Charlotte Department of Transportation

Memorandum

Subject: Rezoning Petition 08-128: Located on the west side of Statesville Road between Twin Lakes Parkway and Future I-485 (*revised 8/15/08*)

Title: **SITE PLAN**

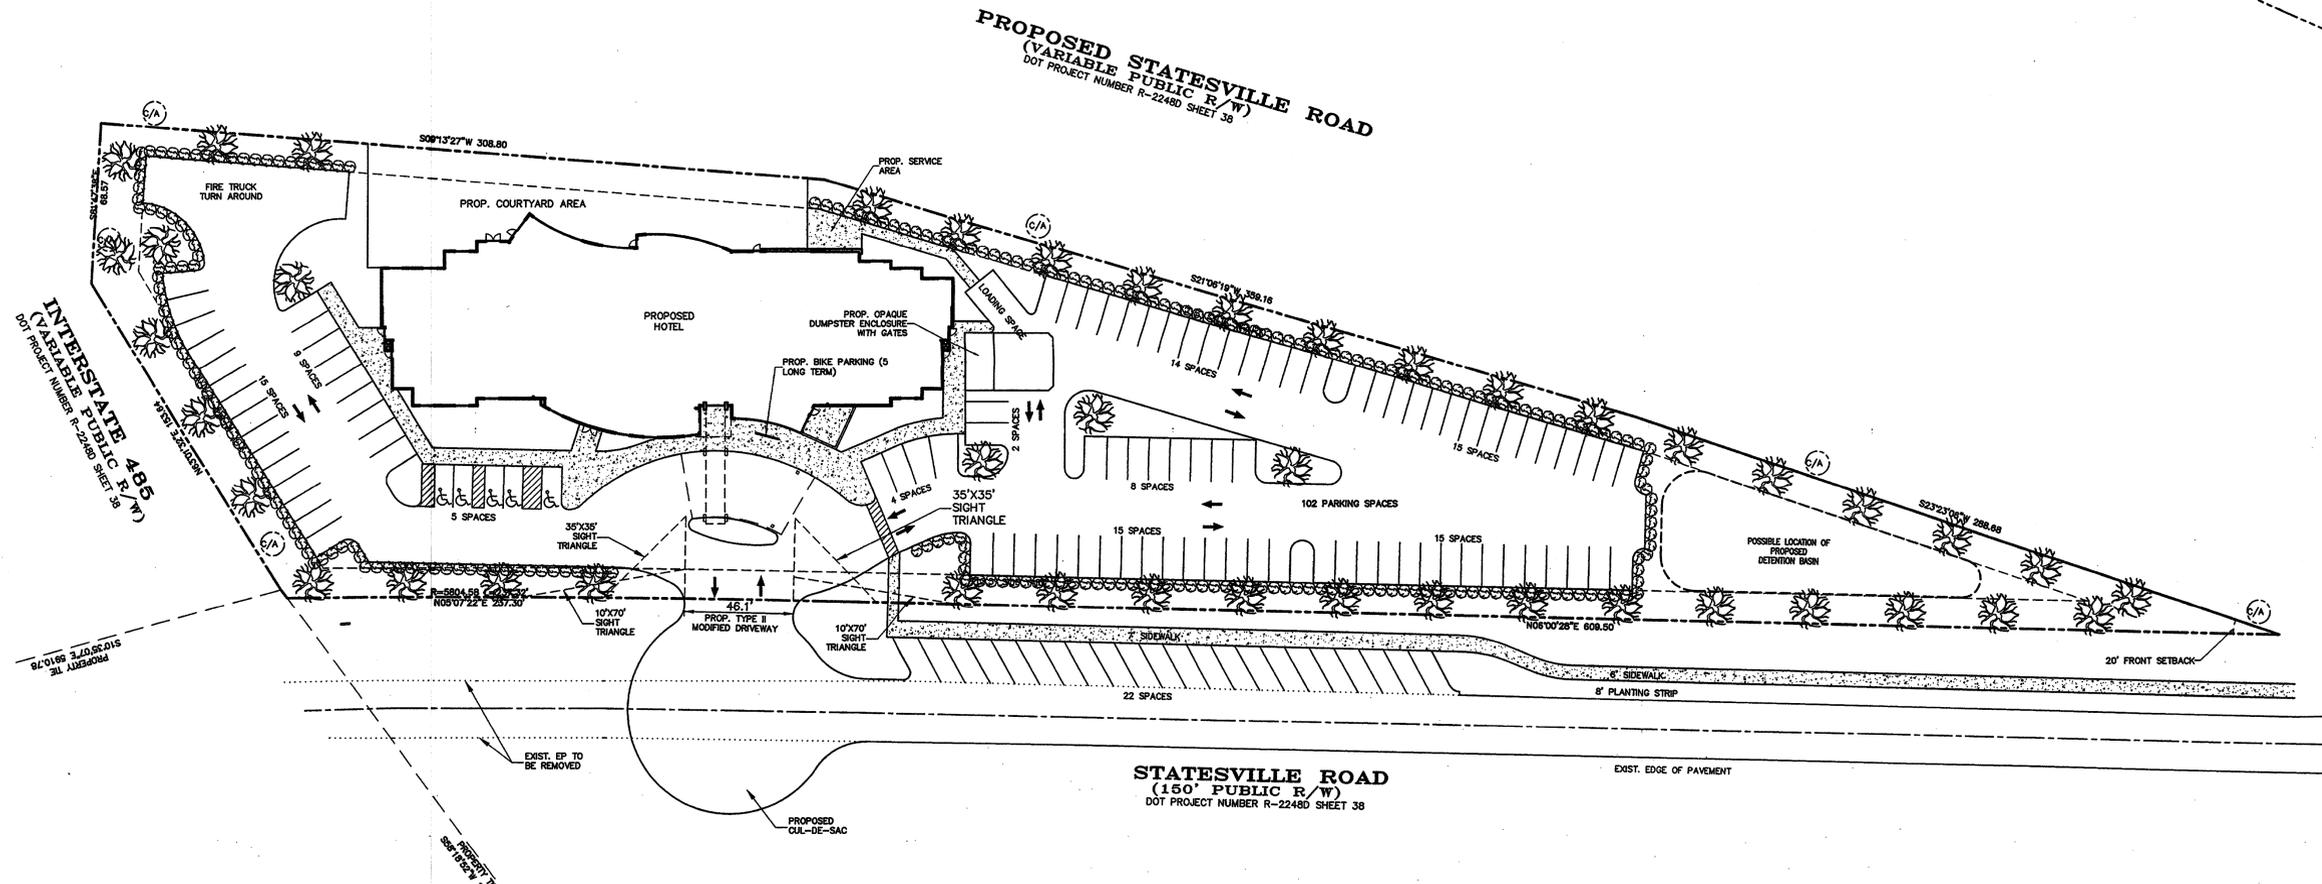
1. The developer needs to construct a 10-foot width multi-use path running a minimum of 25-feet outside the right-of-way of and parallel to the new alignment of Statesville Road.
(*Previous review comment*)
2. It is our understanding that the petitioner has requested the NCDOT to abandon this section of Statesville Road. Whether or not the right-of-way is abandoned, its connection to new Statesville Road cannot be in its current skewed alignment. The connection must be

designed to connect at 90° and will likely impact the proposed detention basin shown on the site plan. The redesigned access to new Statesville Road needs to be shown on the site plan.
